# **Sheringham Shoal and Dudgeon Offshore Wind Farm Extension Projects**

Traffic and Transport Discussions with  
Norfolk County Council

Title:	
<b>Sheringham Shoal and Dudgeon Offshore Wind Farm Extension Projects Examination submission Traffic and Transport Discussions with NCC</b>	
PINS document no.:	
Document no.:	
Date:	Classification
<b>10.01.2023</b>	<b>Draft</b>
Prepared by:	
<b>Royal HaskoningDHV</b>	
Approved by:	Date:
<b>Sarah Chandler, Equinor</b>	<b>XX</b>

**Table 1-1 NCC Comments on SEP and DEP DCO documents and the Applicant's response**

TITLE  
B1149 OULTON  
DRAFT  
ACC25 ACCESS DESIGN  
(SHEET 2 OF 2)

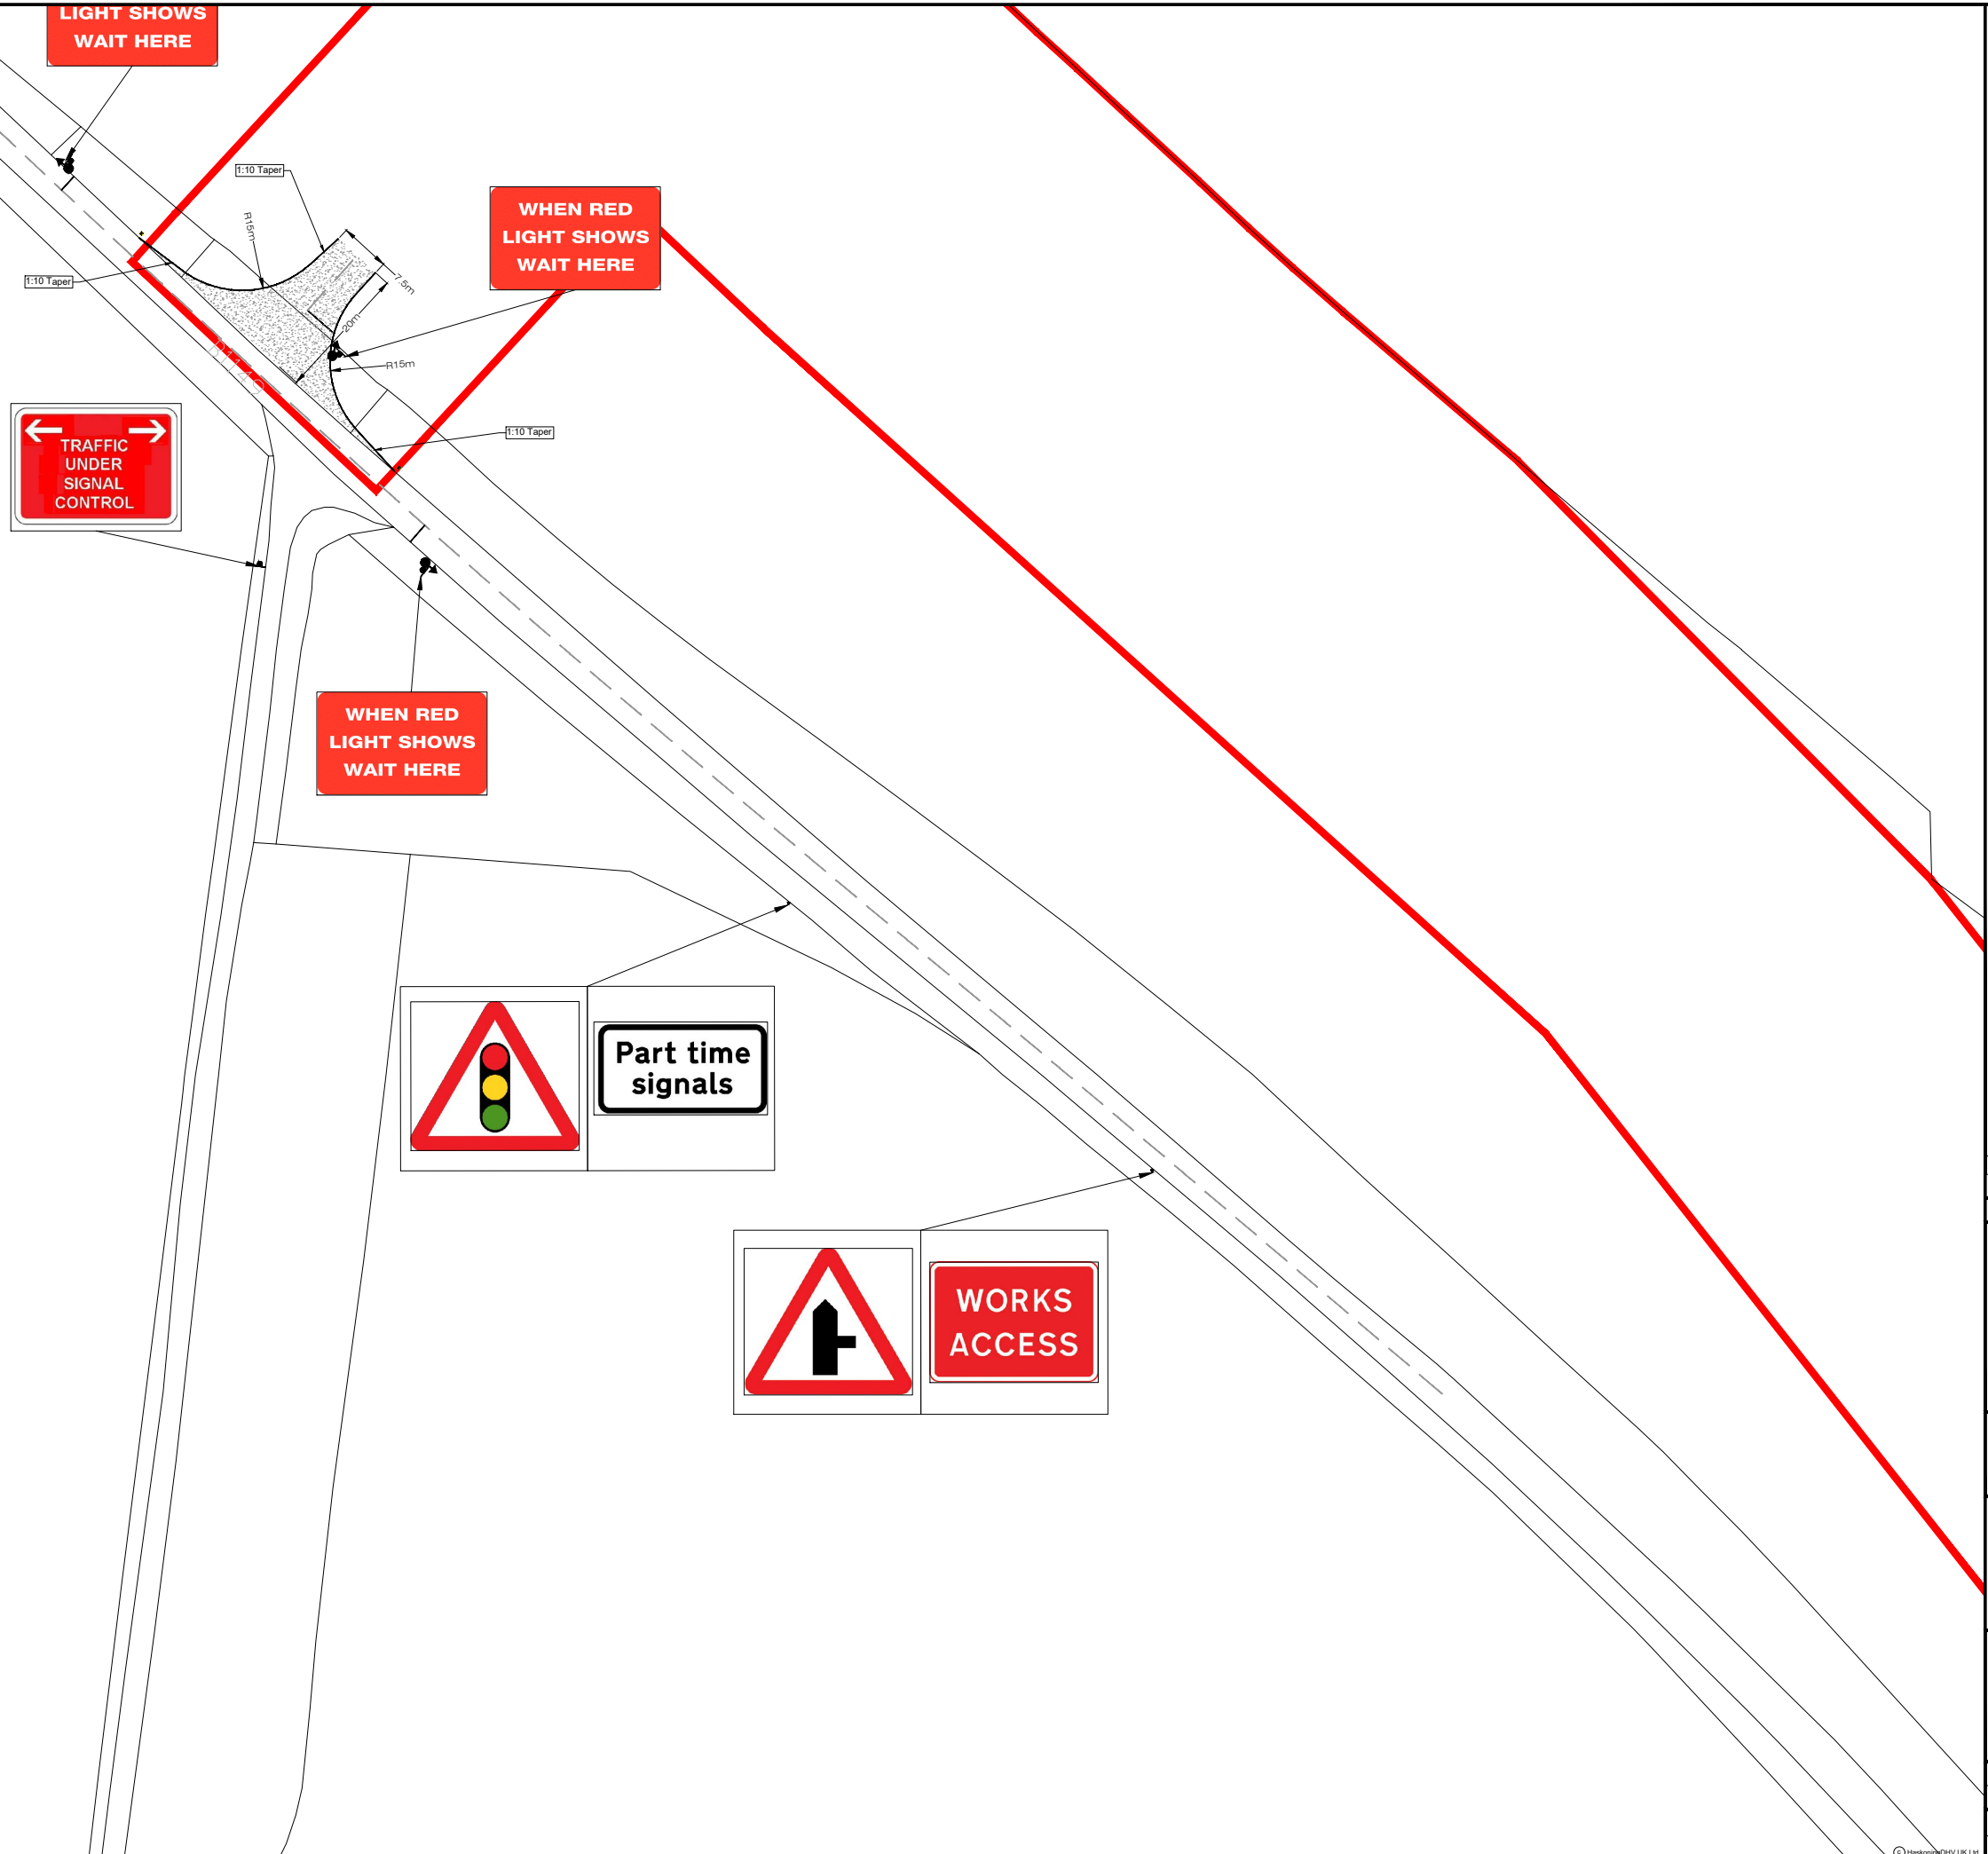
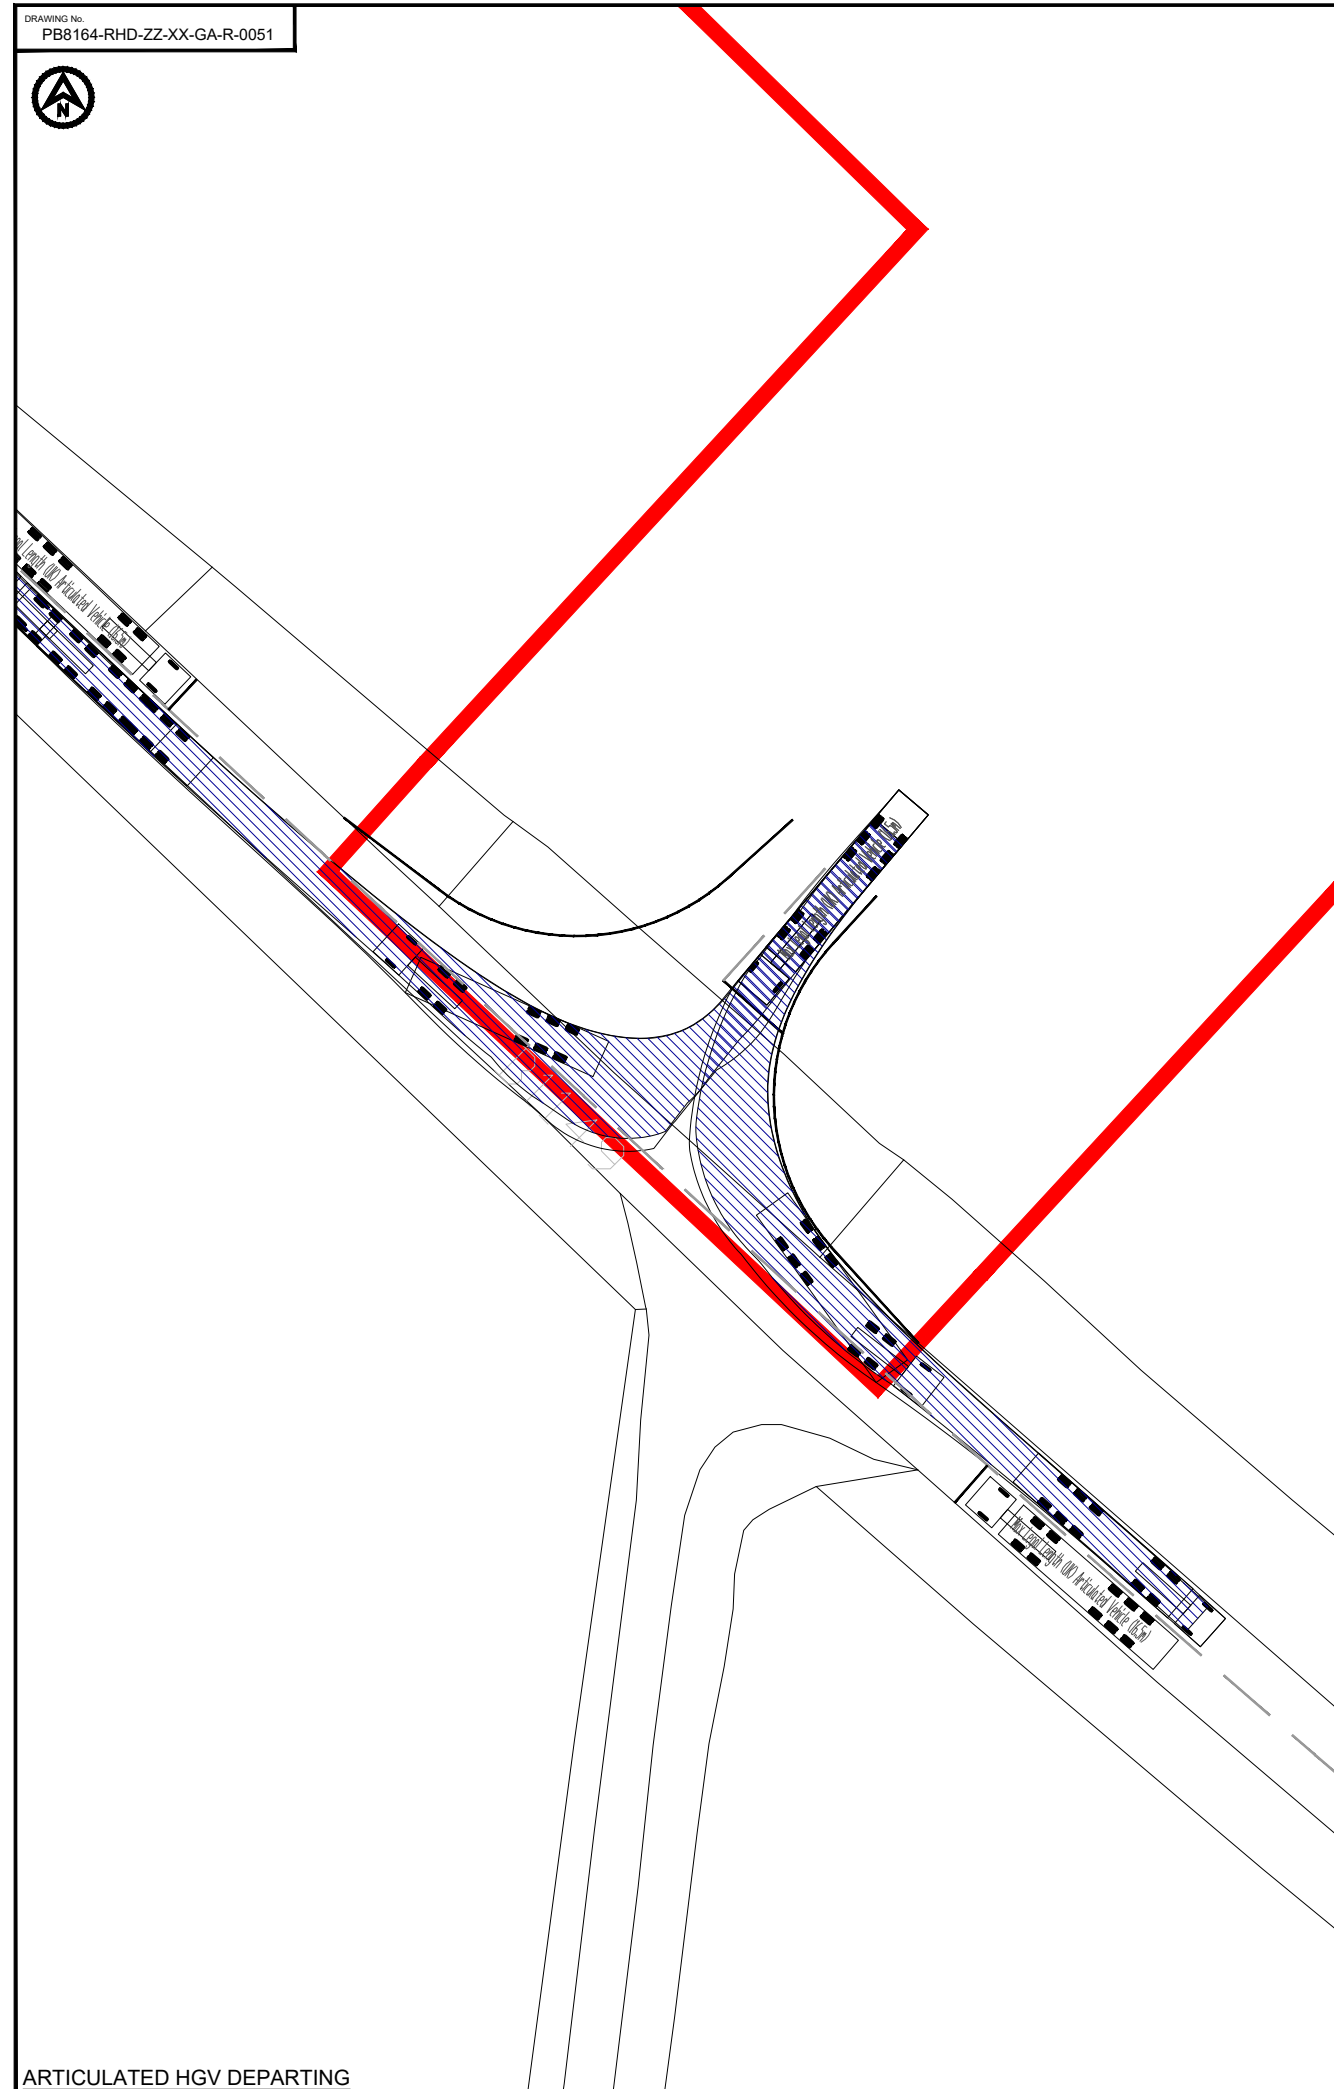
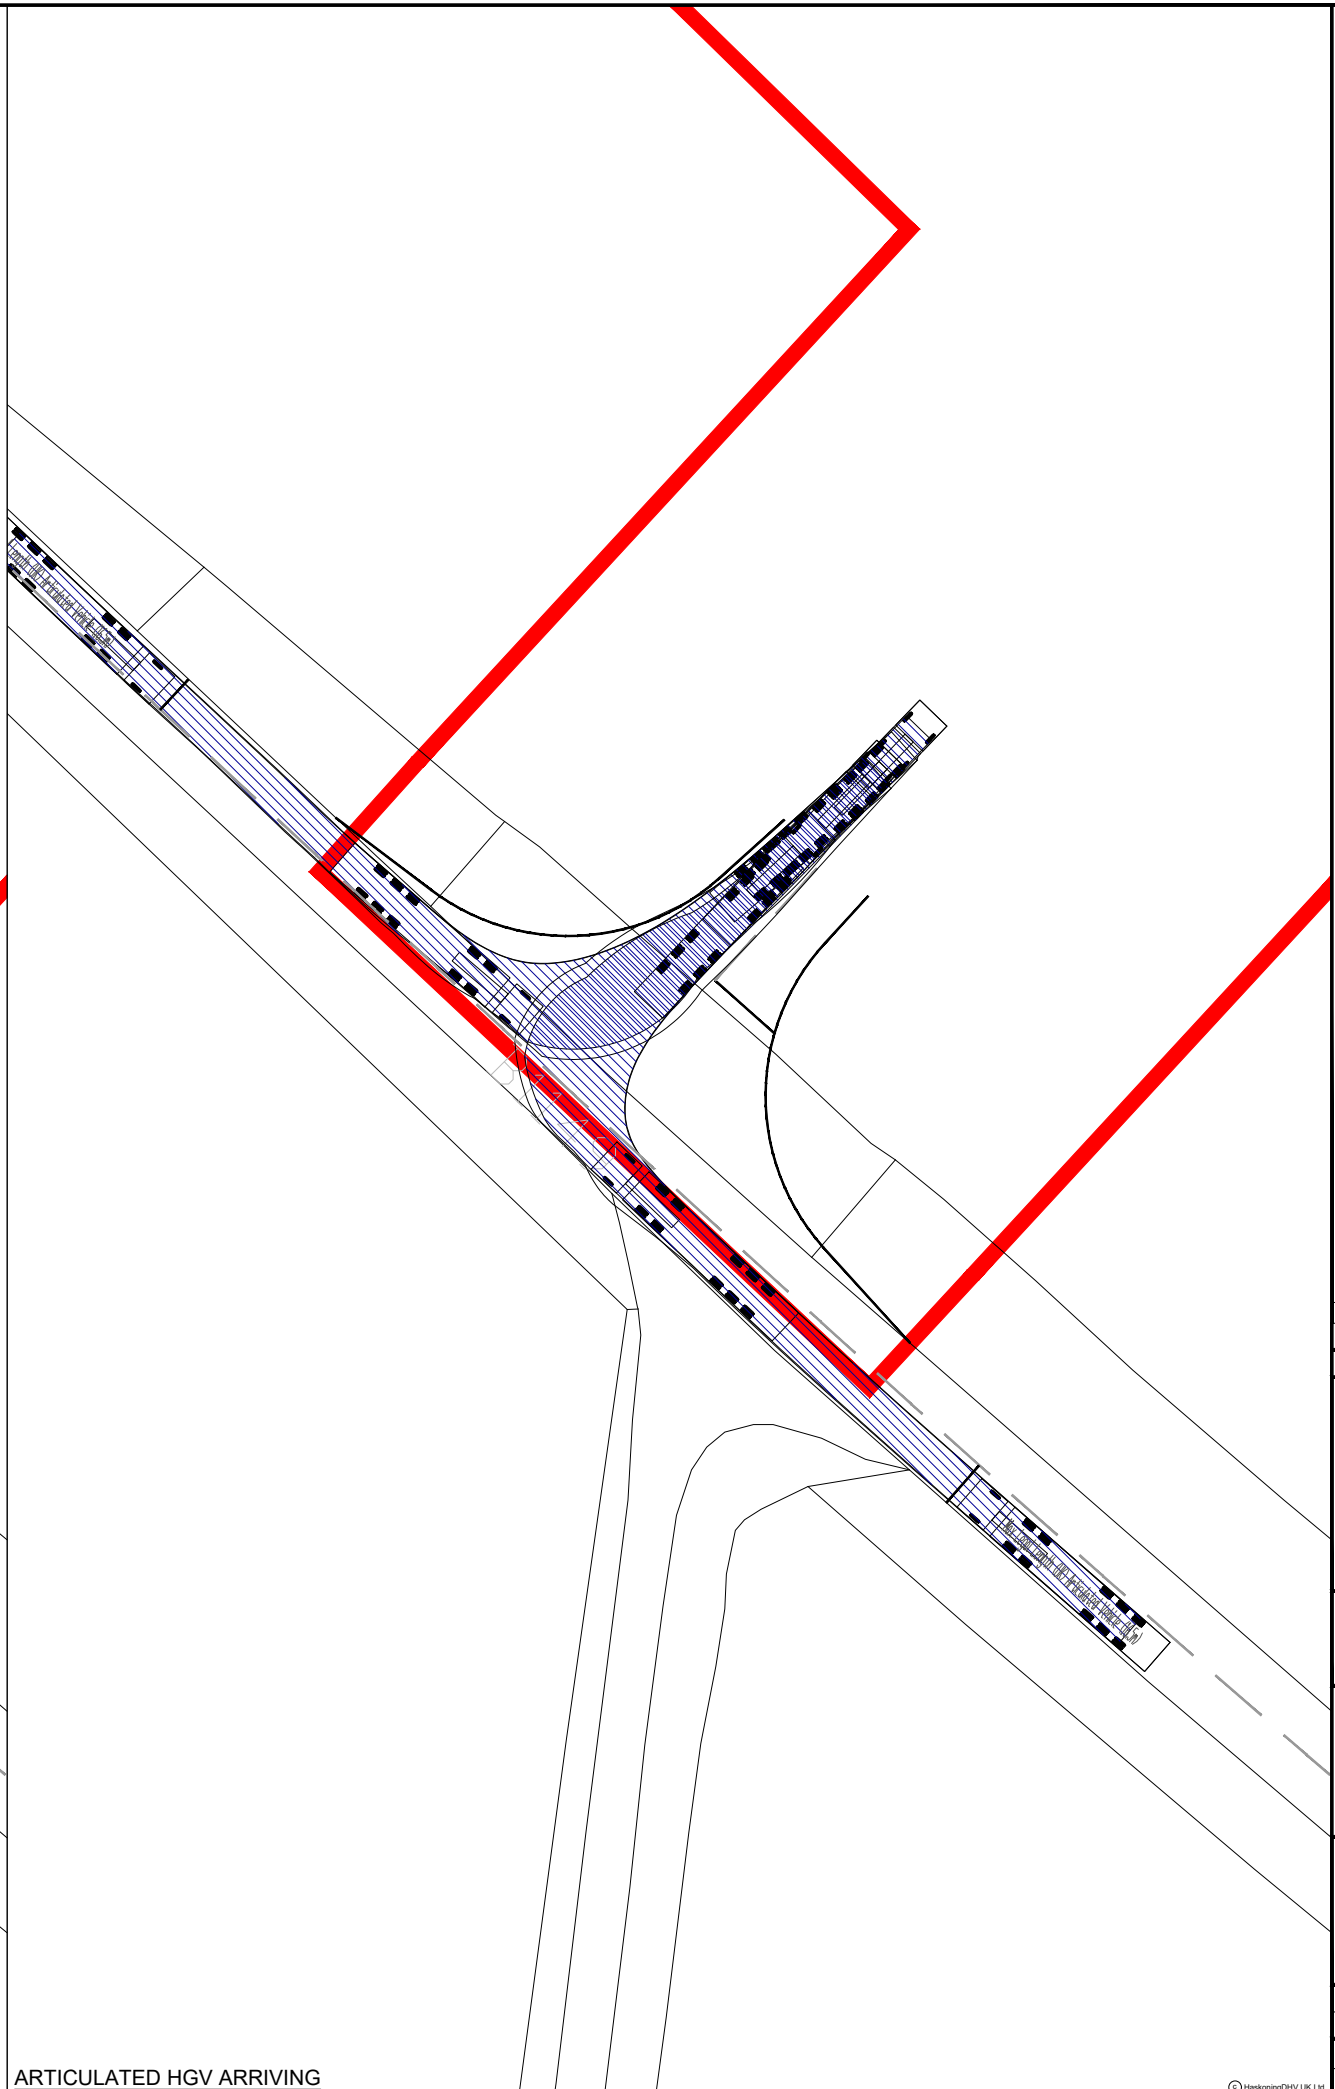
18		Sheet 15 Oulton on B1149 – We may ask you to restrict access times dependant upon clarification of use.	Annex 19 of the TA [APP-269] outlines the forecast numbers of peak daily vehicle trips that could travel to ACC25. This identifies that at peak, there could be up to 50 HGV trips per day, equivalent to three arrivals and three departures an hour. In addition, Annex 23 of the TA [APP-269] identifies that there could be a peak of up to 40 LV trips per day, equivalent to 20 arrivals in the morning and 20 departures in the evening. When considering network peak hours and applying the existing commitments in relation to LV movements (detailed at ID.16) there could be a peak of five LV and five HGV trips during the defined network peak hours. The Applicant considers that the existing substantive commitments in relation to managing LV trips would ensure that there are no significant impacts upon capacity at ACC25.	NCC confirmed that they are content with the clarification provided and that the measures outlined within the OCTMP to manage traffic movements are appropriate.
